**Re: AI-Faisal College, Austral (SSD-10445)**

Council welcomes the opportunity to provide comments on the above State Significant Development (SSD-10445) at 66-80 and 83-87 Gurner Avenue, Austral. It is noted that Council previously provided a response to the SEARs request in April 2020, and this submission should be read in conjunction with that submission.

OVERALL SITE PLAN

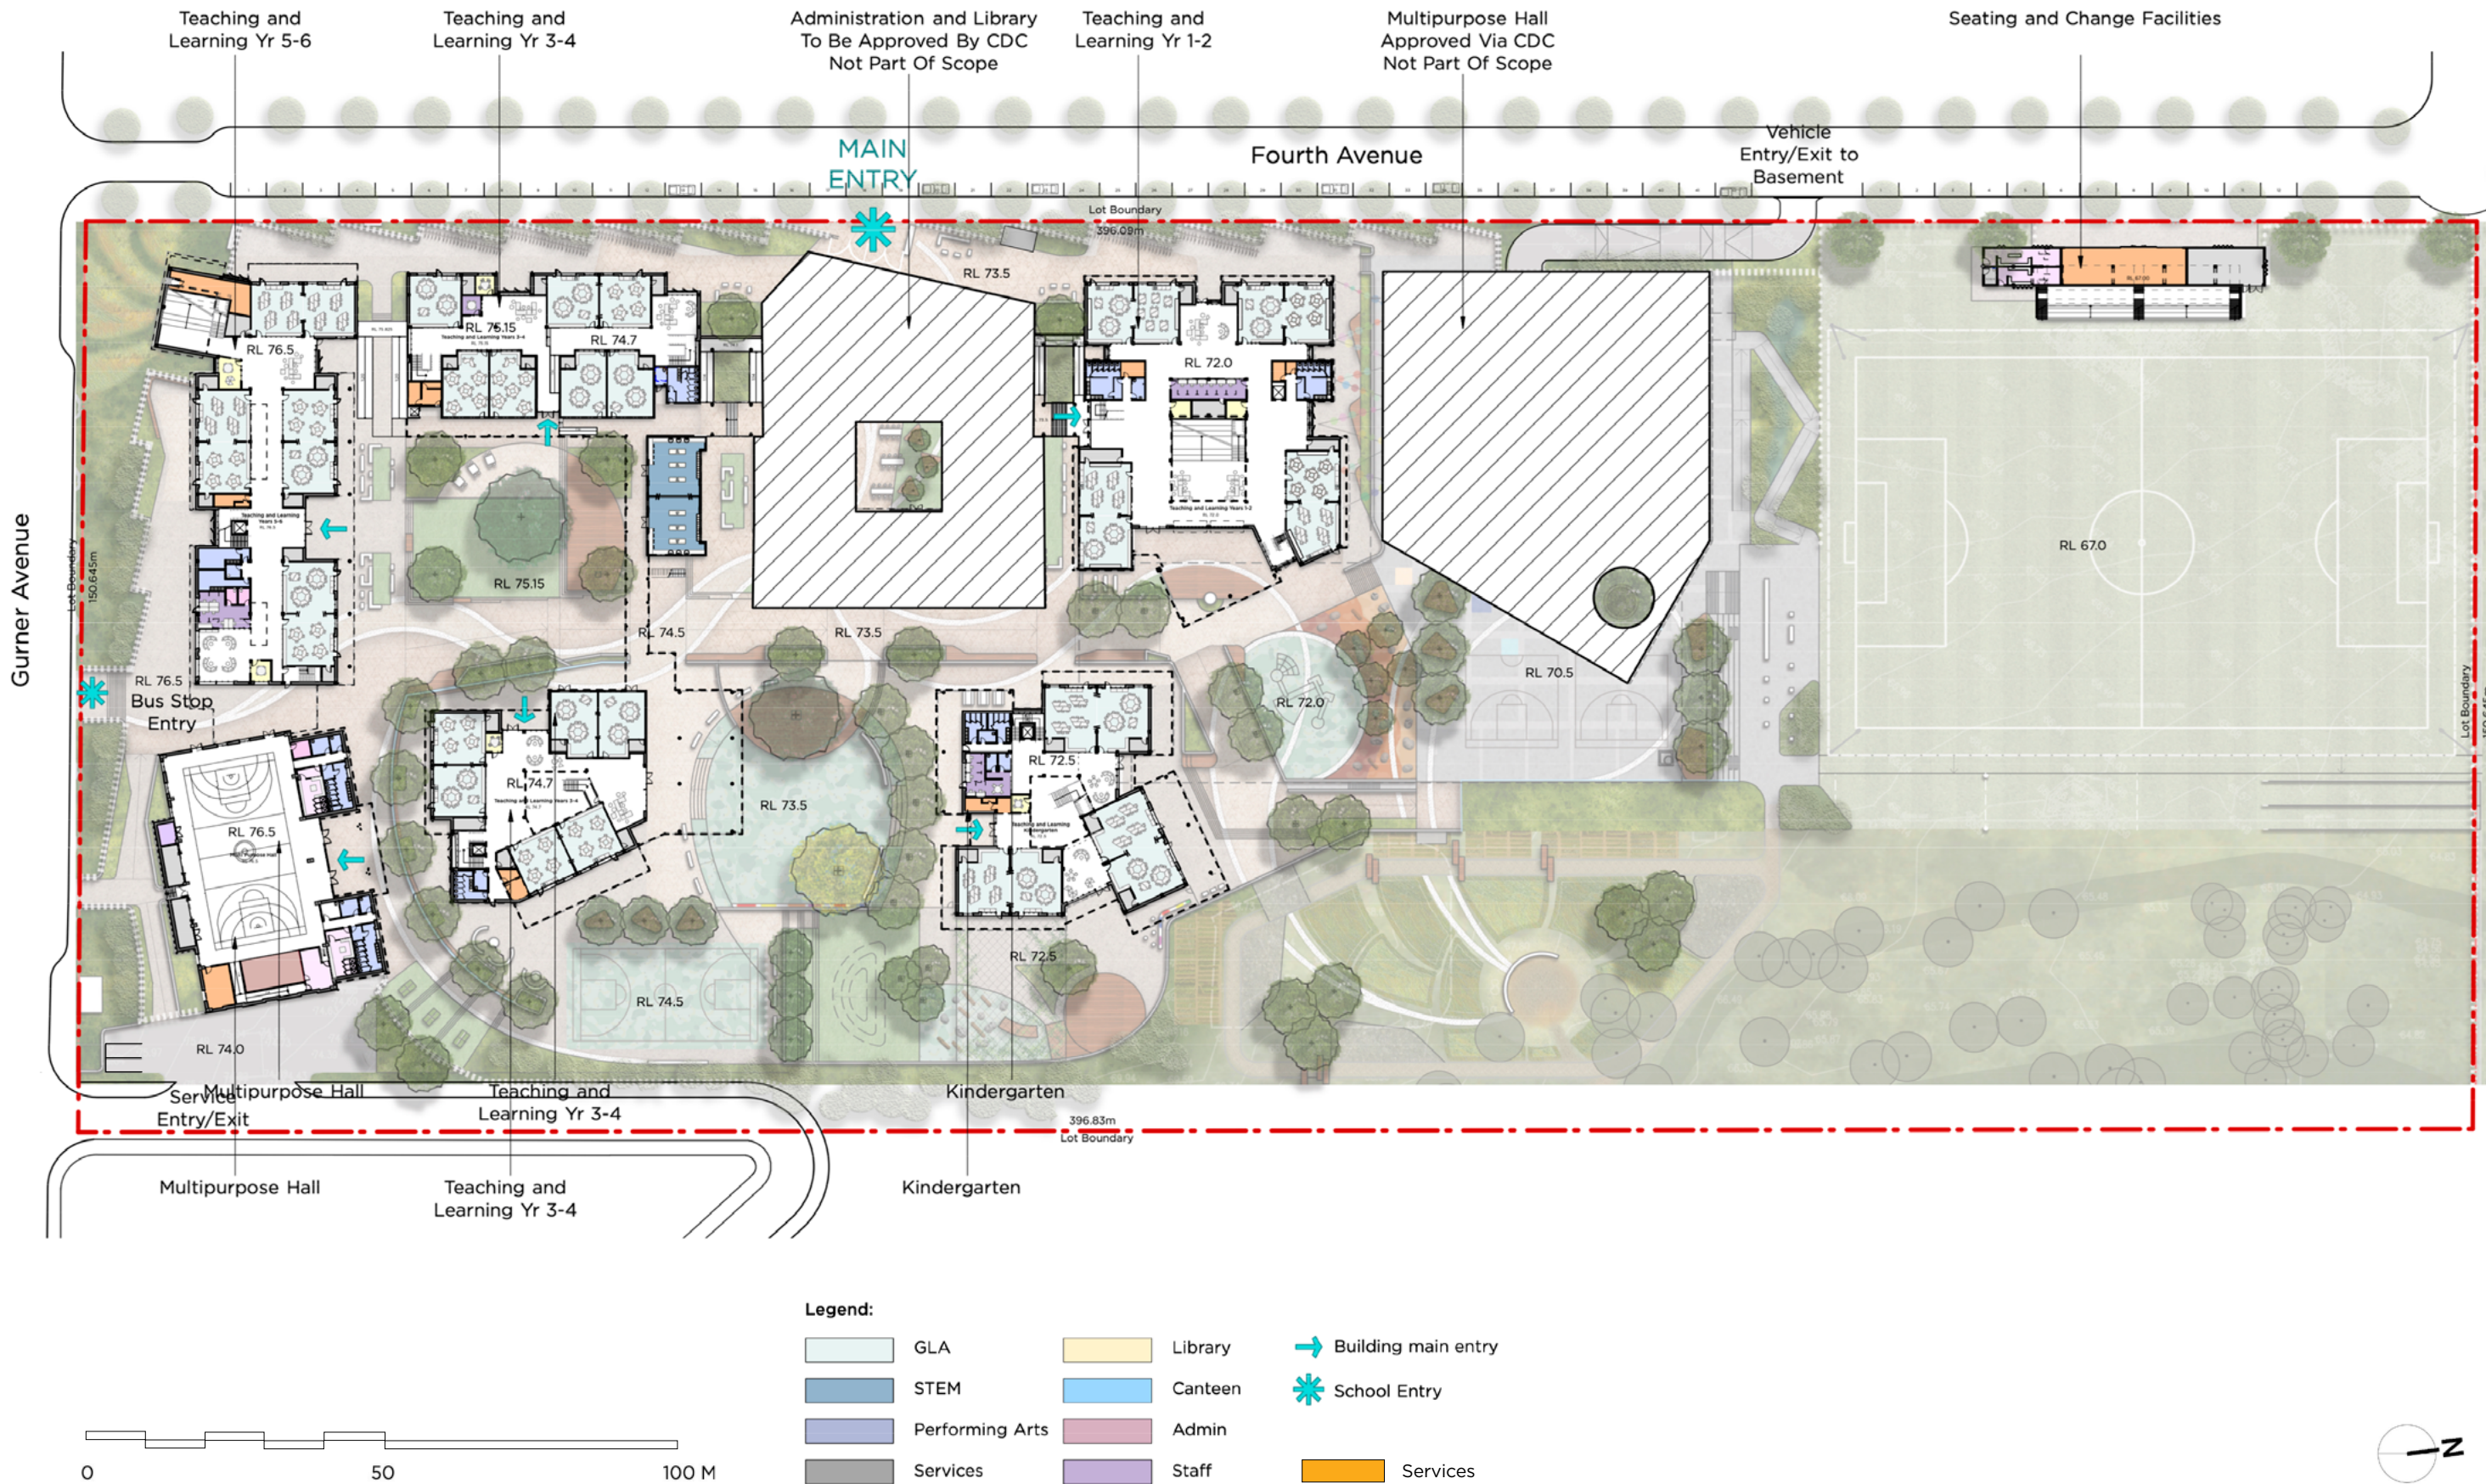
Clarification is needed whether a building within the proposed primary school site will be constructed on land zoned RE1 Public Recreation. A number of images / figures indicate that a building is proposed on RE1 land, while the EIS states (page 94):

Please refer to *Figure 3-1 Primary School Masterplan* from the submitted Flood Impact Assessment and *01 Site Plan Primary School – LO (Ground)* from the Submitted Architectural Plans.

It is noted that the land to which the building is proposed in the RE1 Public Recreation zone is not biocertified. A building being constructed on the RE1 zoned land is not supported.

- DPIE to clarify if any part of the school is to be located on land zoned RE1 Public Recreation.
- DPIE to clarify the permissibility of the school on RE1 zoned land and impacts of non-bio-certified land.
